RE: 39 Mayfield Street

Please find response to your comments for the Single Family Site Plan at 39 Mayfield Street. The surveyor for this project is James Mullen, PLS of Spurwink Survey. Please find updated plans from him and Northeast Civil Solutions enclosed.

**GRADING PLAN**  
Project Name:  
**SINGLE FAMILY RESIDENCE**  
29 WAVERLY STREET, PORTLAND ME 04103

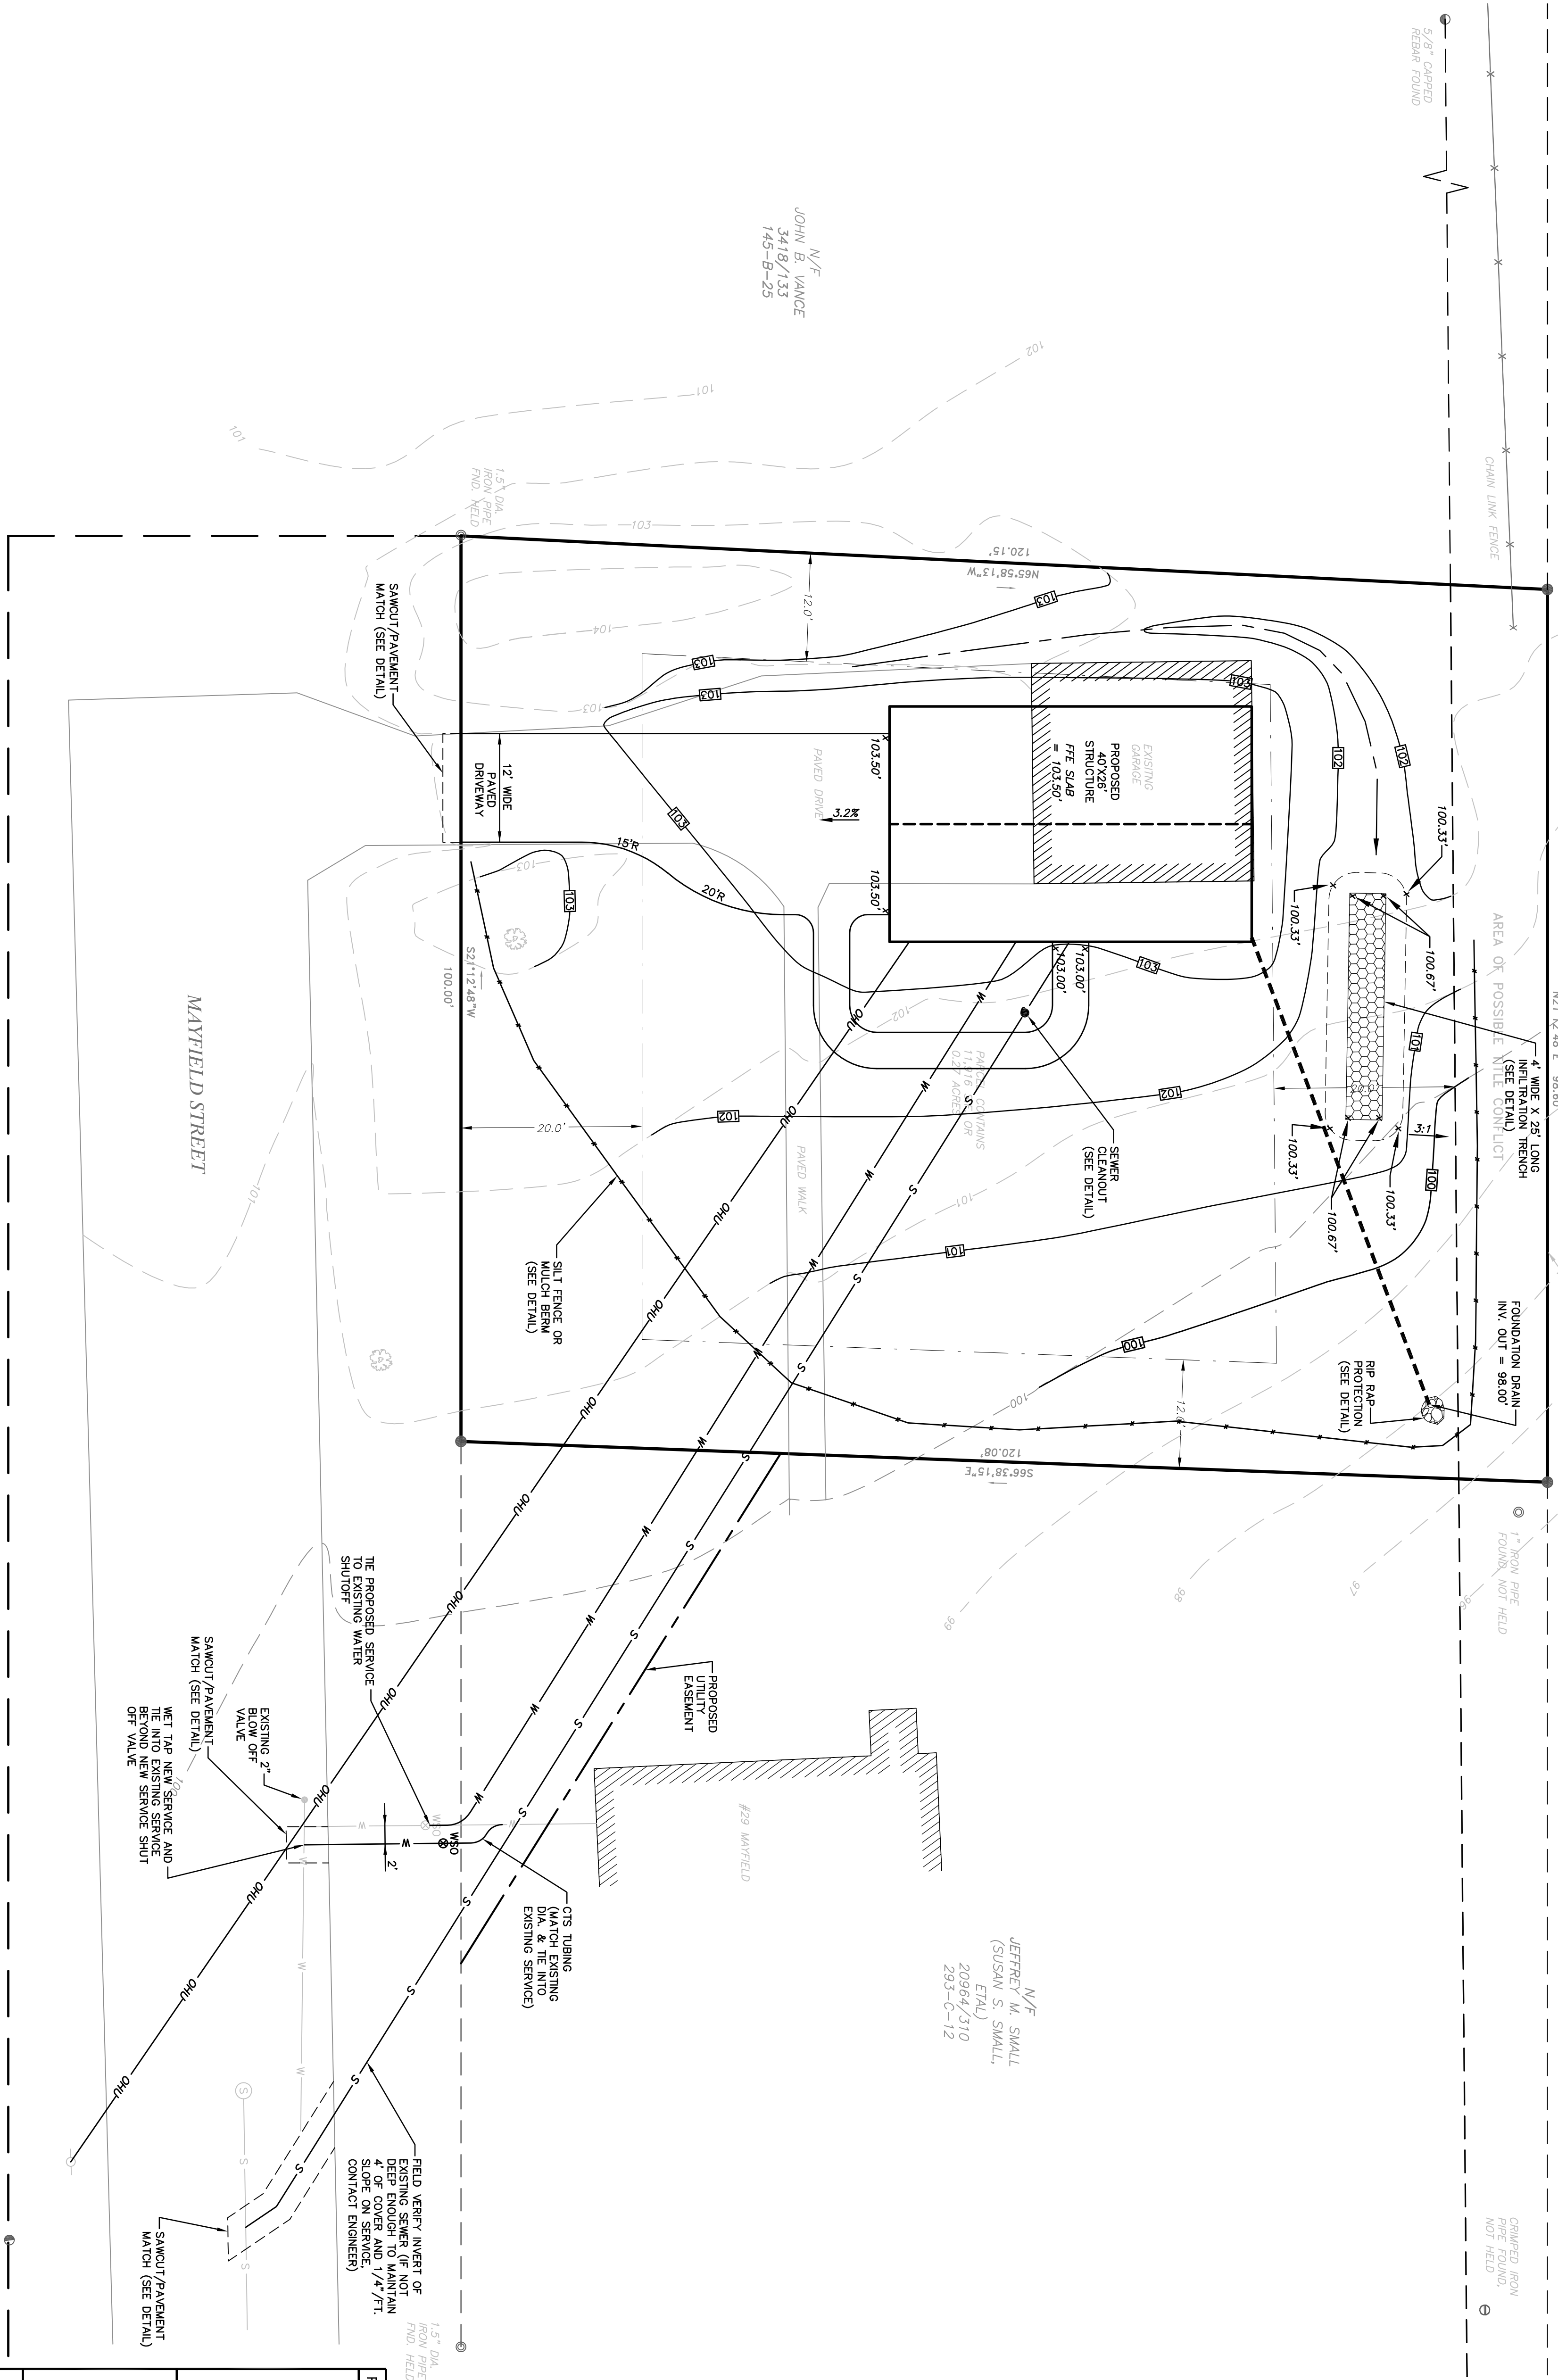
- The location of the 40'x26' building footprint on the grading plan, seems to be centered at the rear of the paved driveway. As it stands the proposed garage would not line up with the driveway. **The building was moved to line up with the driveway/turnaround.**

BOUNDARY SURVEY
MAYFIELD STREET, PORTLAND ME.

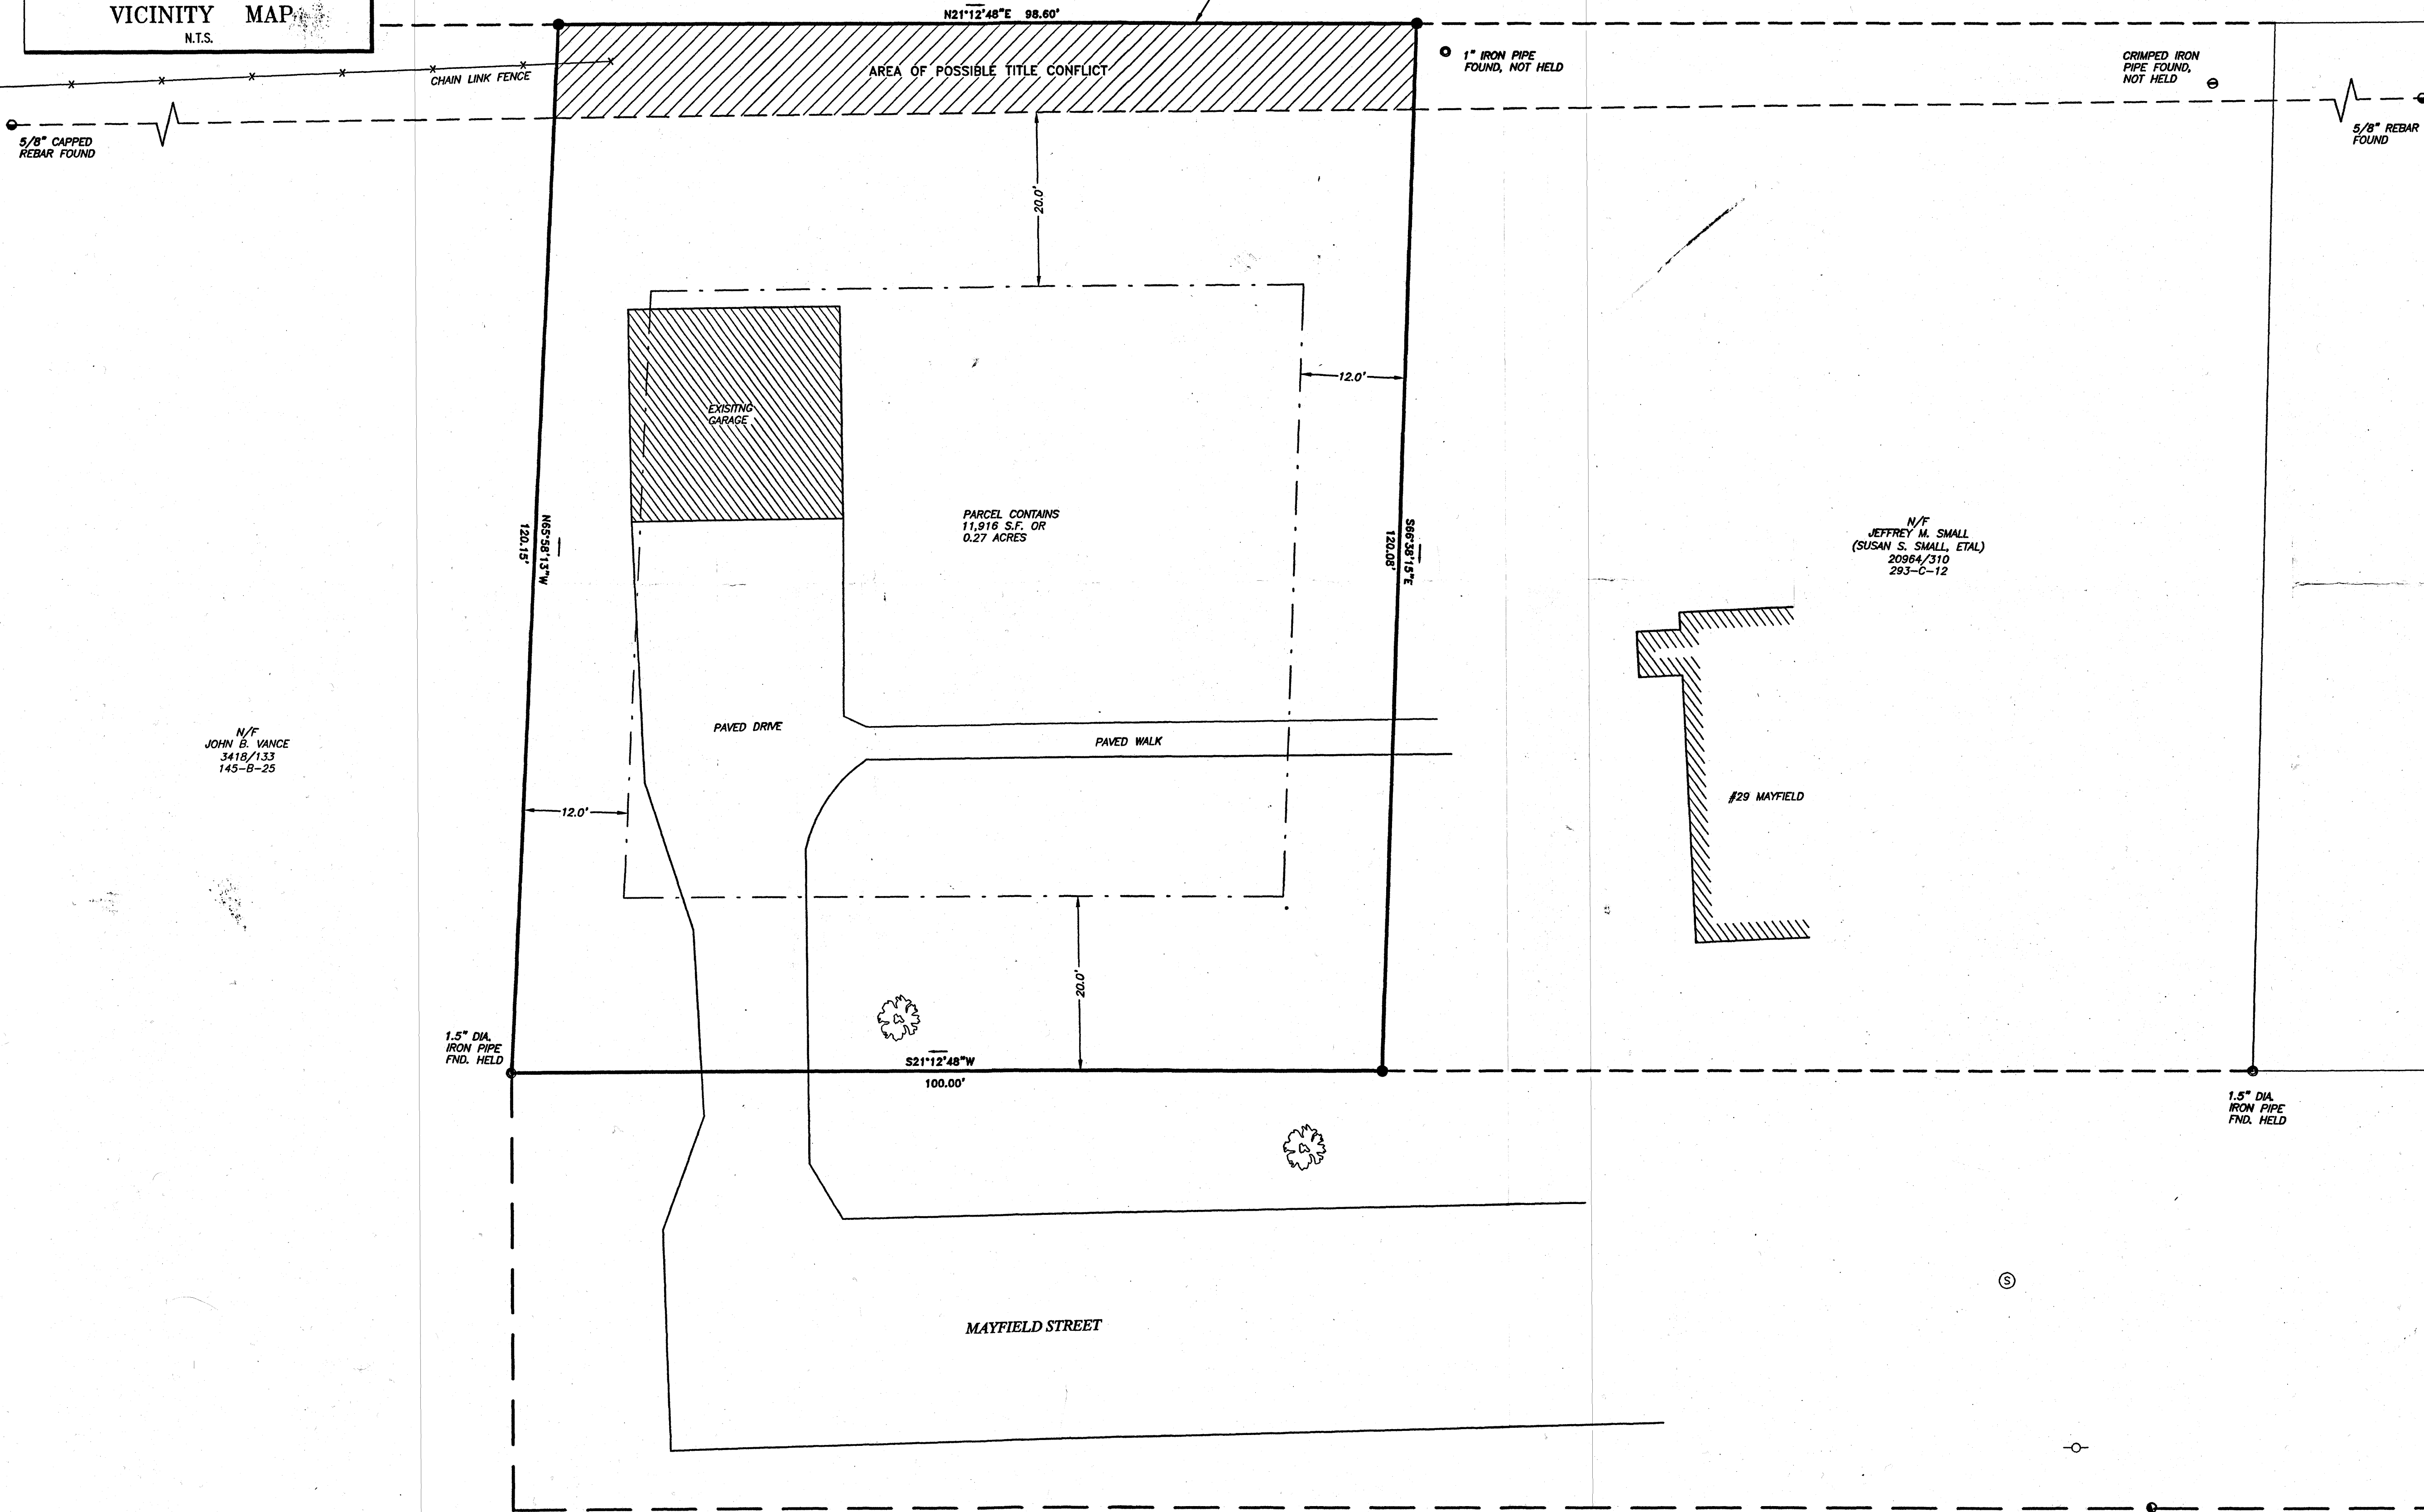
A revised survey plan that meets the survey standards for a Level 1 Minor Residential Site Plan Application has been enclosed for your review.
